From: Karl McLaughlin
Sent: 27 February 2018 16:04
To: Planning.Responses
Subject: RE: Planning Consultation on: BR/20/18/PL

**Change of use of shingle beach opposite the kiosk for the installation of decking with a wooden windbreak to form a seating area.
(BR/20/18/PL)**

**Shingle beach outside Coffee Cup Kiosk,
Bognor Regis Esplanade,
Bognor Regis PO21 1NY**

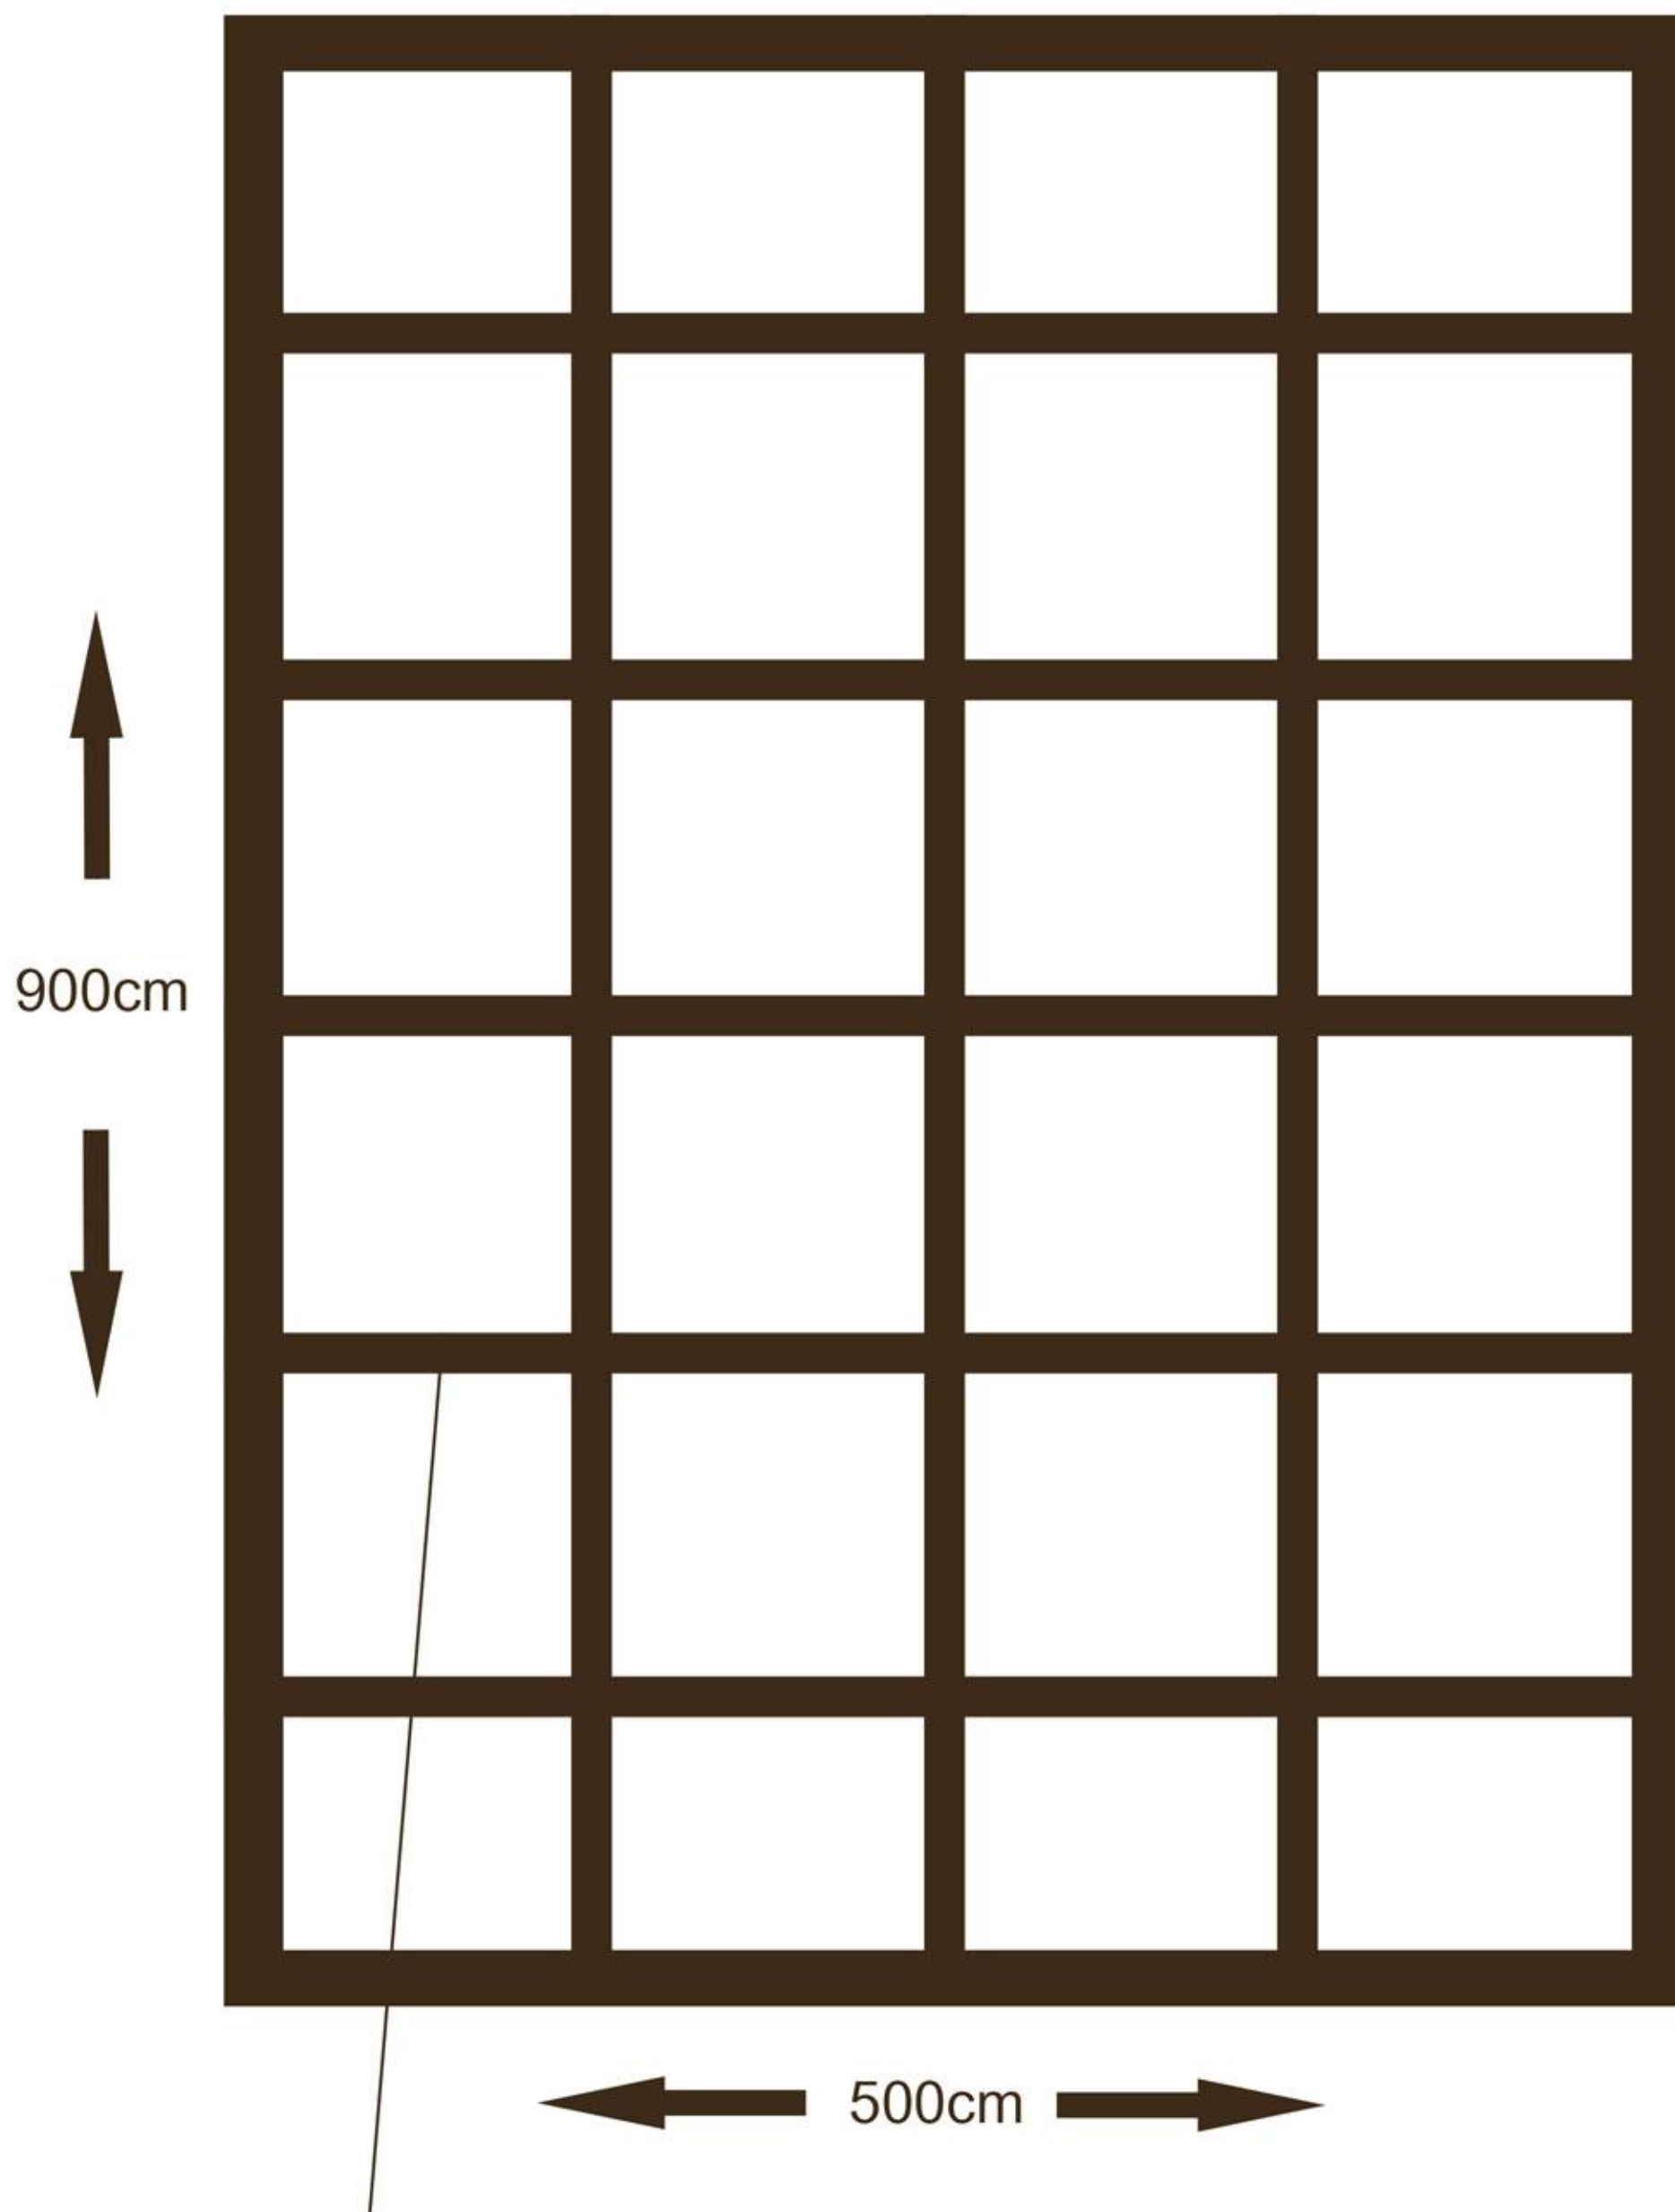
Coast Protection have no objection to the aforementioned application. However, It should be understood that the area in which the applicant proposes to install the decking is highly mobile. The nature of shingle beaches is such that Arun District Council cannot, and shall not, guarantee that the crest width will remain sufficient to maintain the structure. In the event of the asset being damaged or destroyed through storm activity it will be the responsibility of the applicant to remove the debris on the next working tide.

Additionally, we would advise that if approved, this application have the following condition is attached. **The applicant shall be responsible for maintaining the structure in perpetuity, or until such time that the asset is removed, to the satisfaction of the LPA.**
